Office of
Environment
& Heritage

DOC17/629242
SSD 8373

Notice of Exhibition - Alexandria Park Community School Redevelopment, Park Road, Alexandria

ATTACHMENT 1 – Office of Environment and Heritage (OEH) comments on Alexandria Park Community School Redevelopment, Park Road, Alexandria

Figure 4: 1% AEP Flood Extent

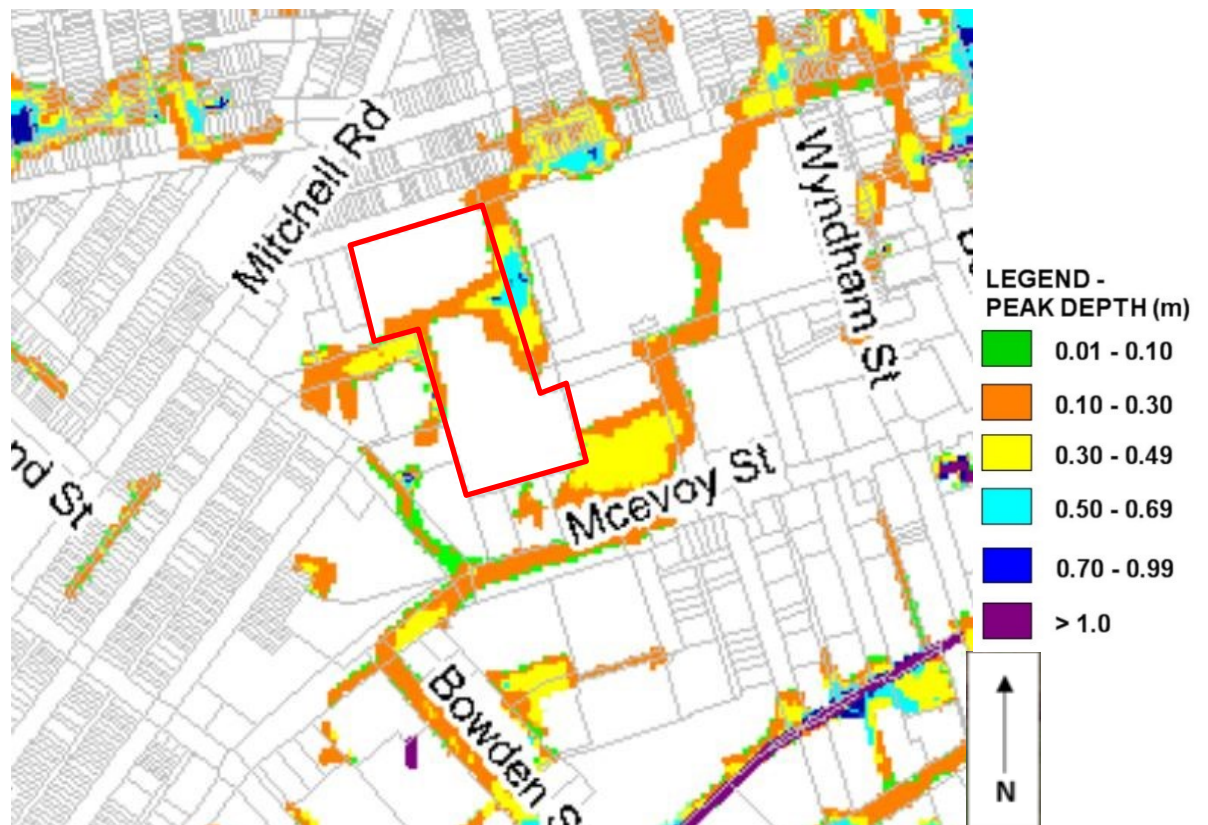
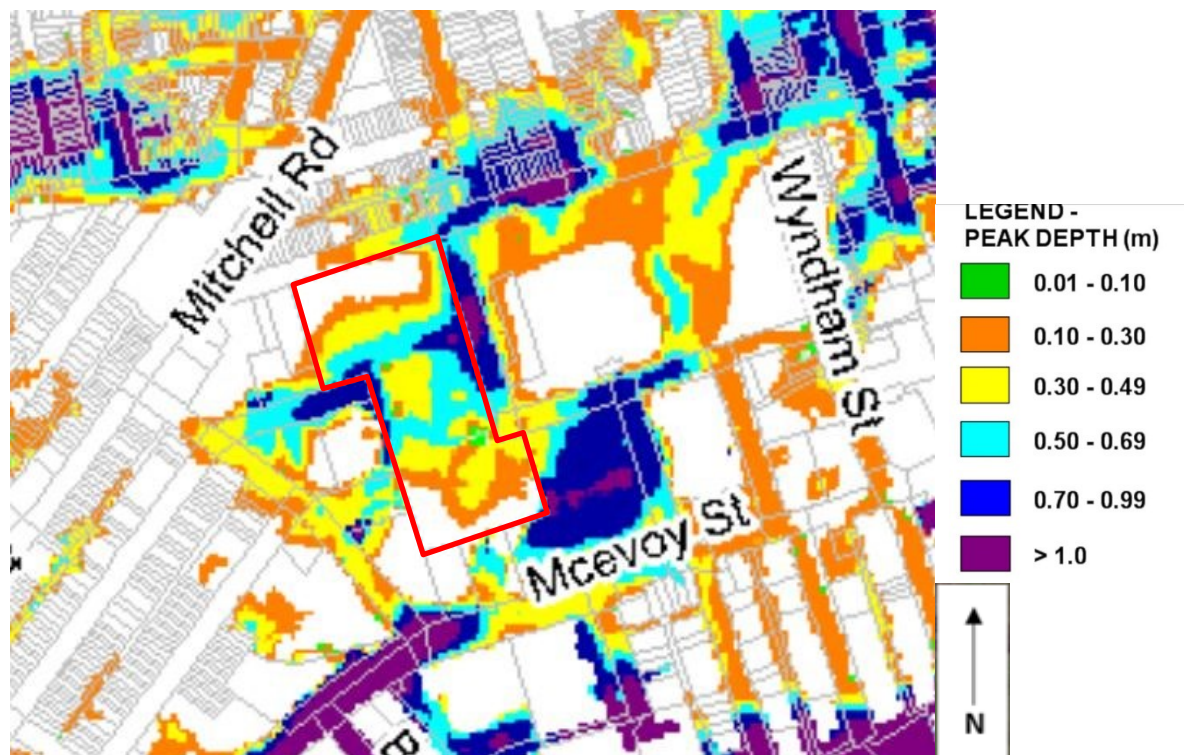
The site is flood prone and is subject to minimum floor level requirements of 13.83m AHD (1% AEP + 500mm). The flood risk report states that this will be achieved and that this level is also higher than the PMF.

The site has evacuation issues and a flood evacuation plan for shelter in place has been produced, though it is not specific in the details of flood evacuation routes and flood free areas around the school. As the site is in an urban catchment with a short critical duration, shelter in place is appropriate as the buildings will be built to higher than the PMF level.

The flood risk report does not provide any details as to the location of the new development on site plans. If the new buildings on the site are within the flood extent, OEH recommends that a flood impact assessment be undertaken. If significant landscaping and regrading of the site is also proposed, this should be included in the flood impact assessment.

- the assessment should adequately address both existing and post development conditions overland flow behaviour for the full range of events up to the probable maximum flood (PMF).
- the impact of the proposed development on overland flow behaviour (i.e. levels, velocities and duration of flooding) and on adjacent areas should be identified. Post-development condition should have no adverse impact on flood behaviour or on downstream areas and should not increase the peak discharged runoff than existing conditions.
- appropriate management strategies, if required, to manage any adverse impact of flooding due to the proposed development and to manage any potential risk to people and property within the catchment.
